Rampion Two Offshore Wind Farm

Appendix E5 to the Natural England Deadline 5 Submission

Natural England's Advice on Fish and Shellfish

09 July 2024

Figure 5.16 Predicted Worst Case and Mitigated (DBBC) Behavioural Response Impact Ranges for Sensitive Features from the Piling of Monopile Foundations (135dB SELss)

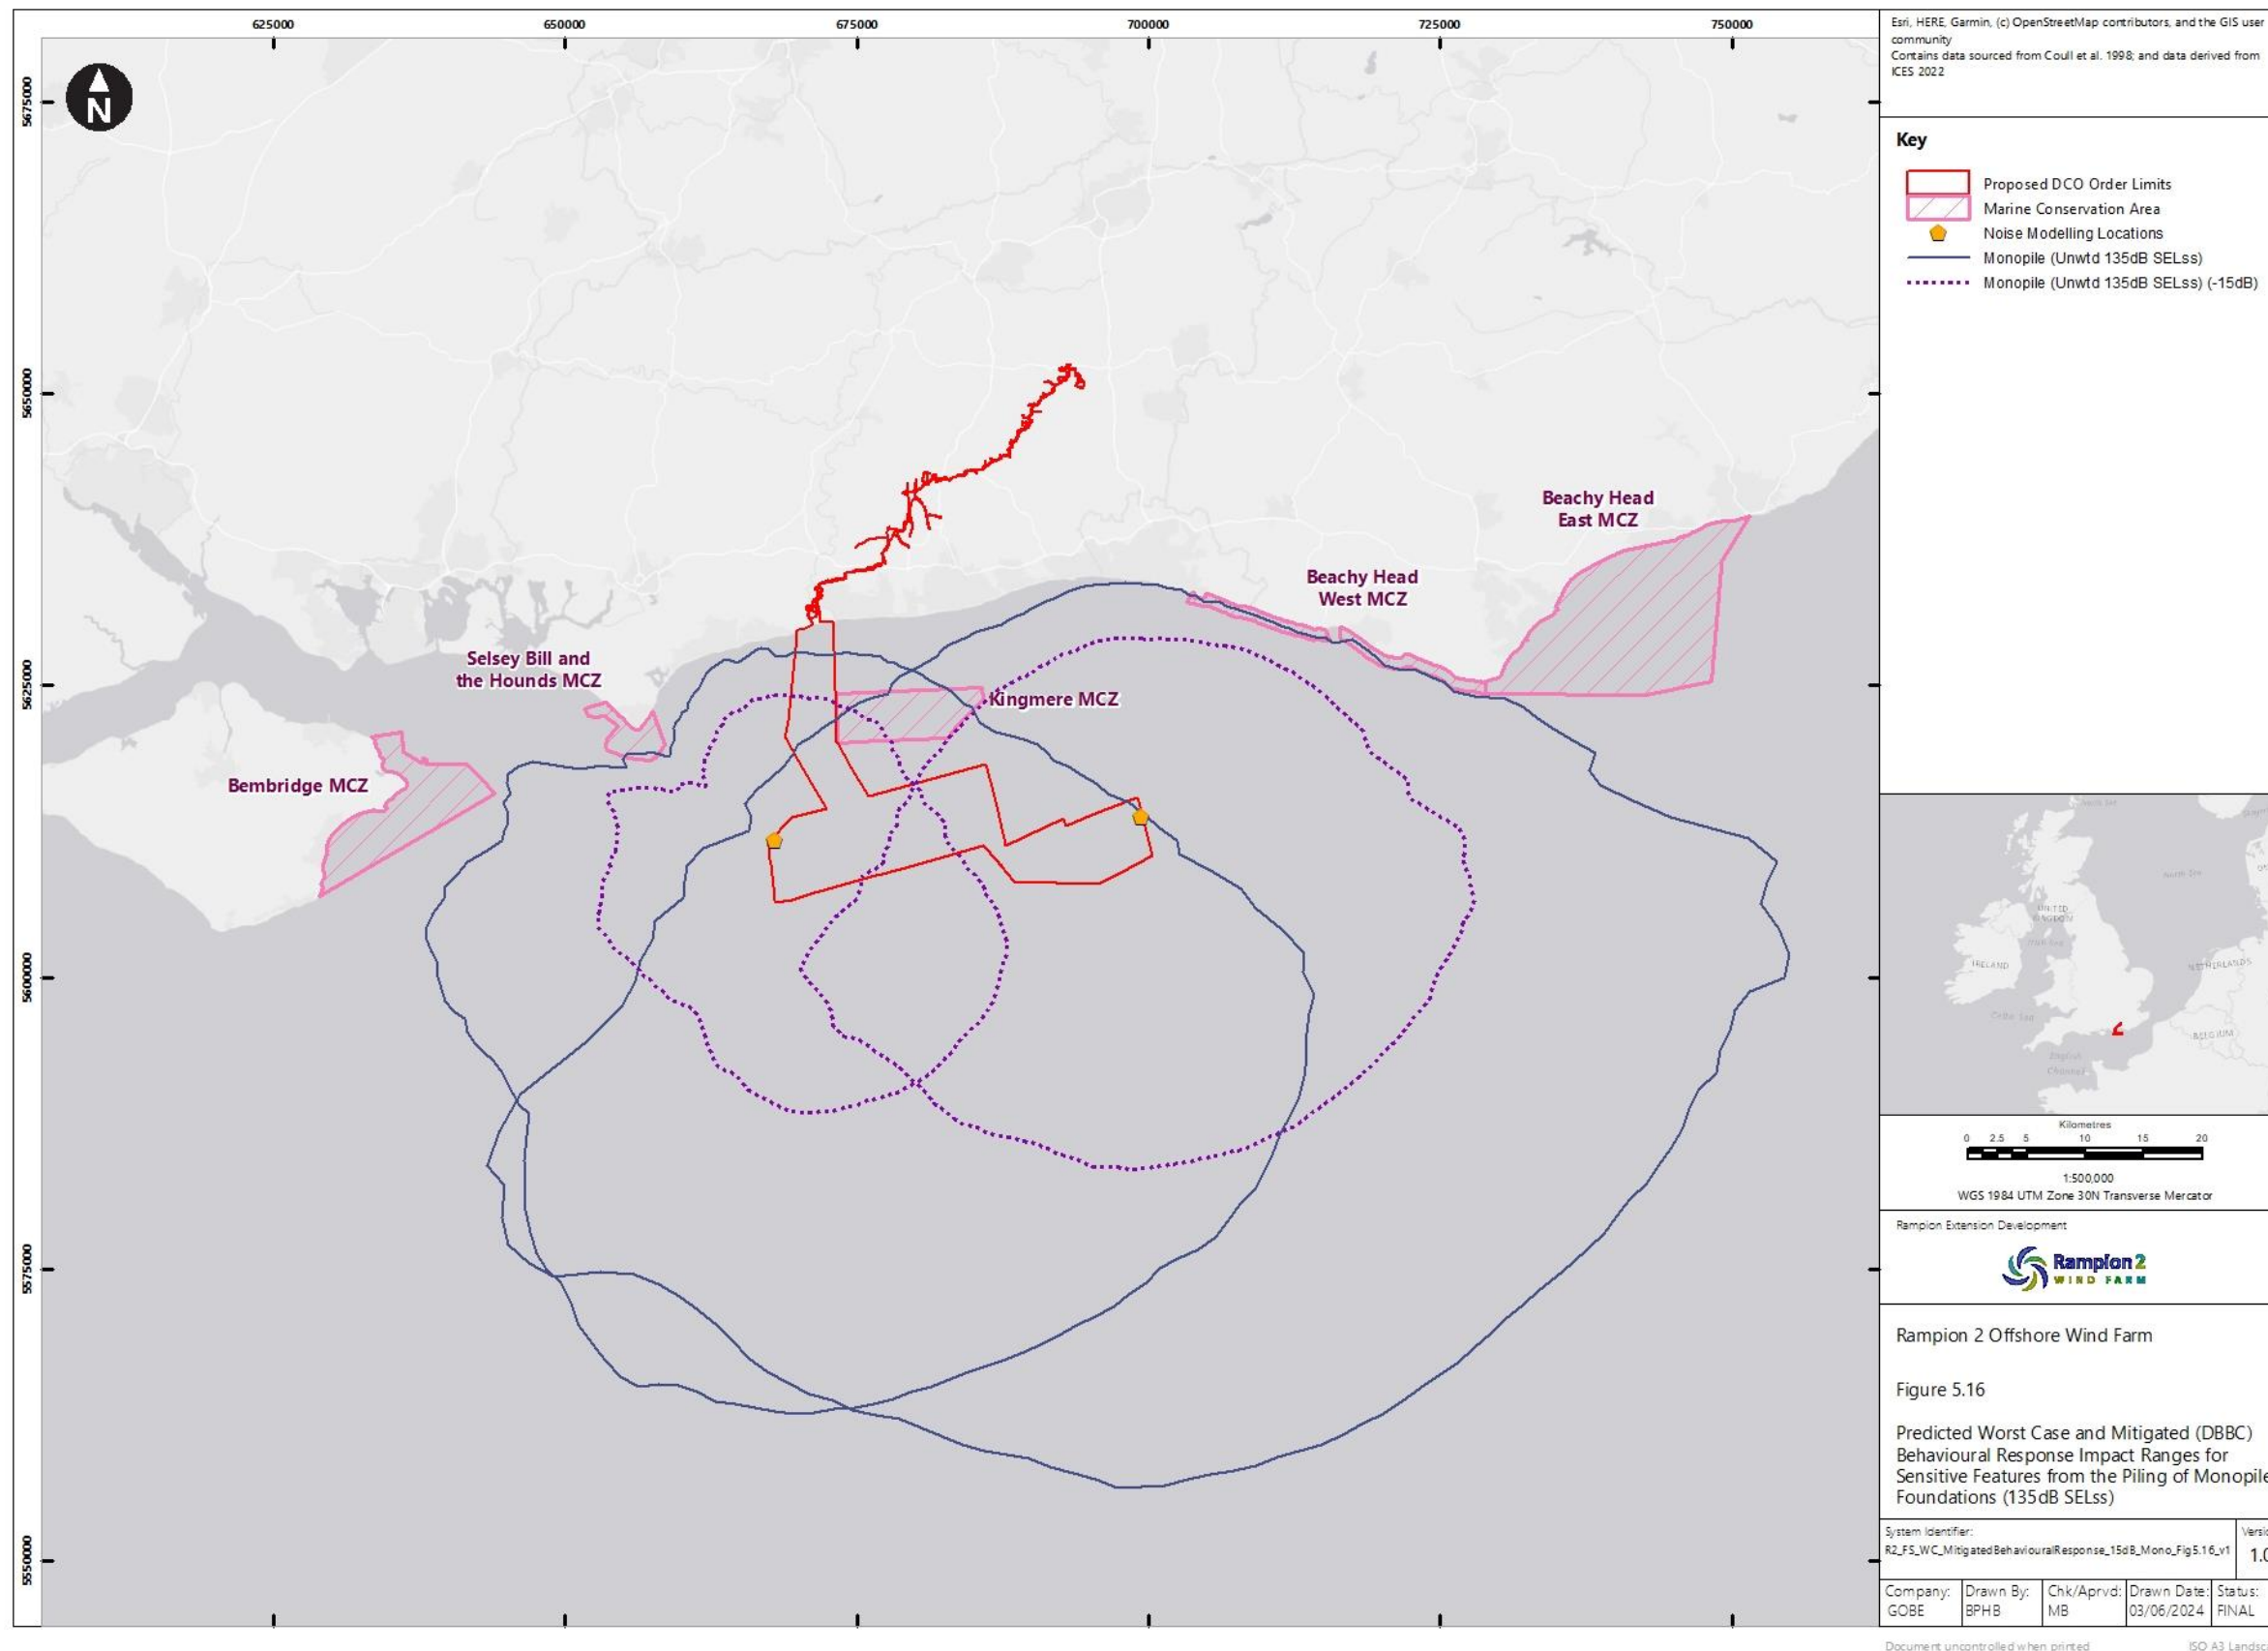
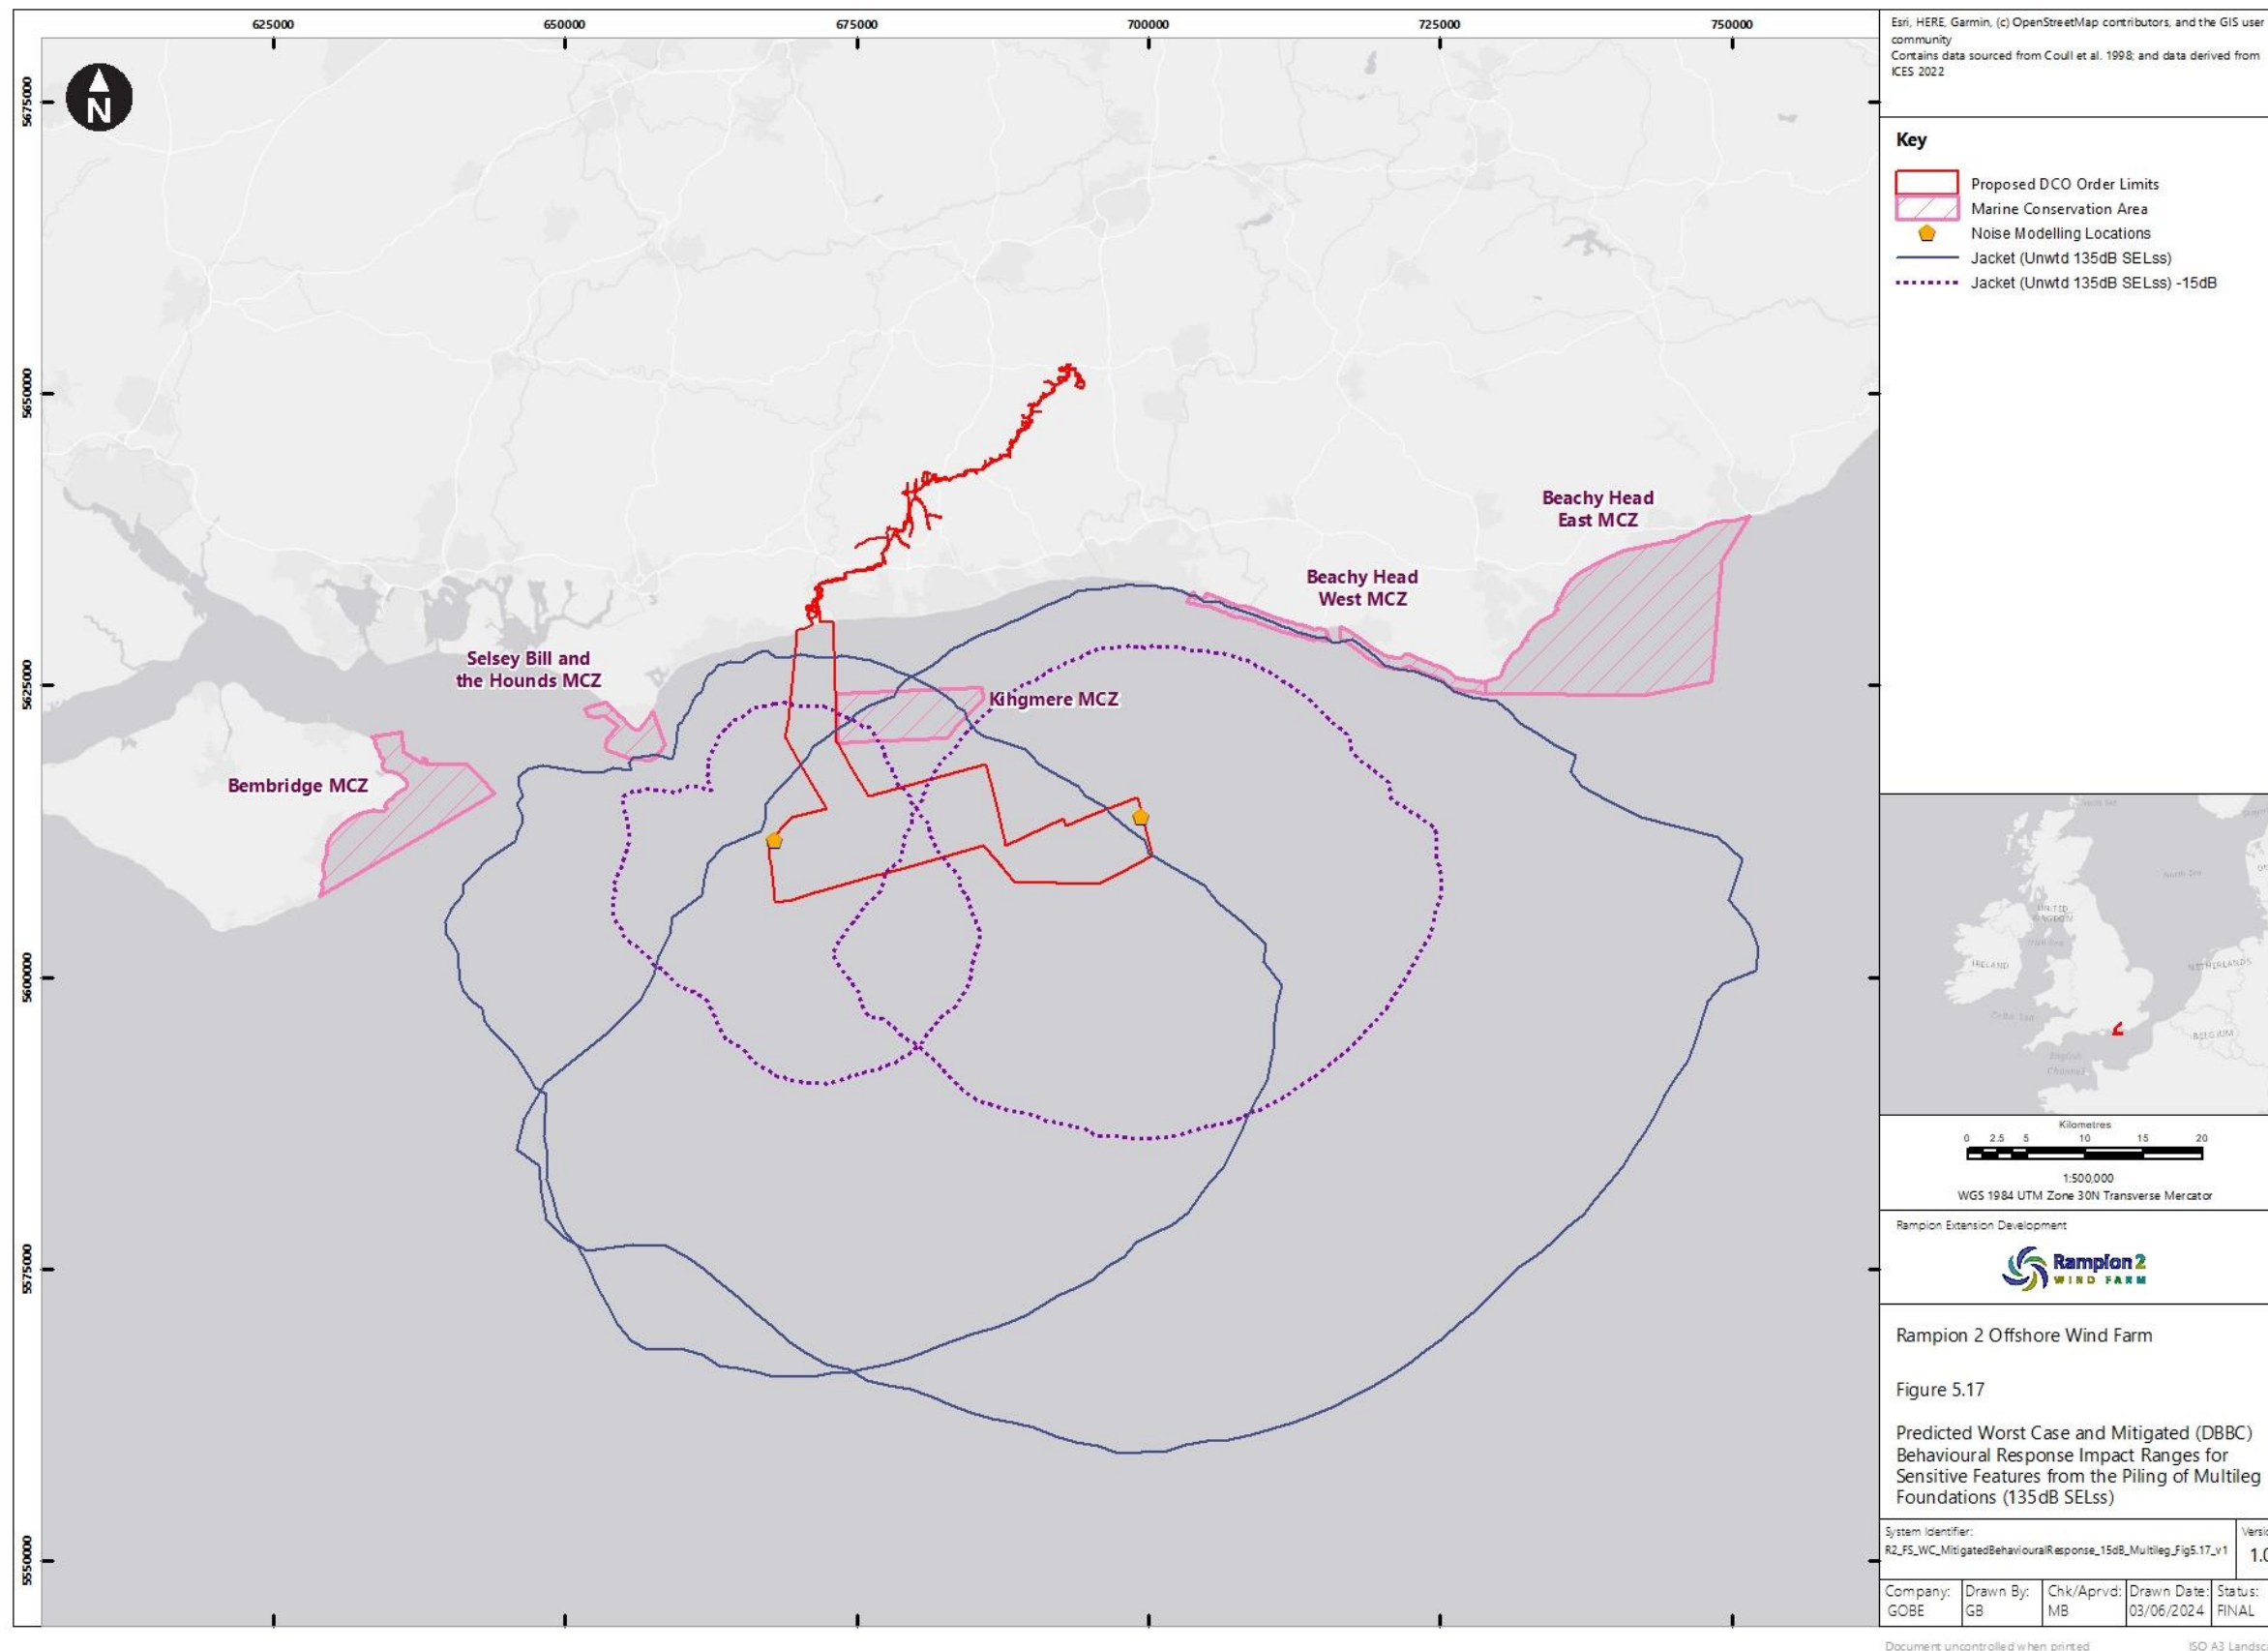
We note that the selected modelling locations impact the amount of overlap of the noise contours with designated sites. Whilst we do not support the use of the 135dB behavioural threshold in relation to black seabream, we have the following observations to make based on Figure 5.16 and Figure 5.17 of the In Principle Sensitive Features Monitoring Plan (IPSFMP) [REP4-054]. We highlight that Figure 5.16 (monopiles) shows that even with a 15dB reduction, there is overlap of the 135dB contour with Kingmere MCZ in relation to the western modelling location and a slight overlap from the eastern location. Figure 5.17 (multileg) shows a similar overlap at the western location. We advise that it appears likely that modelling the piling location at the closest point to Kingmere MCZ would result in a greater overlap than is currently modelled, leading to these noise levels occurring over a greater proportion of the MCZ. We advise that this further calls into question the viability of the Applicants proposed mitigation plan.
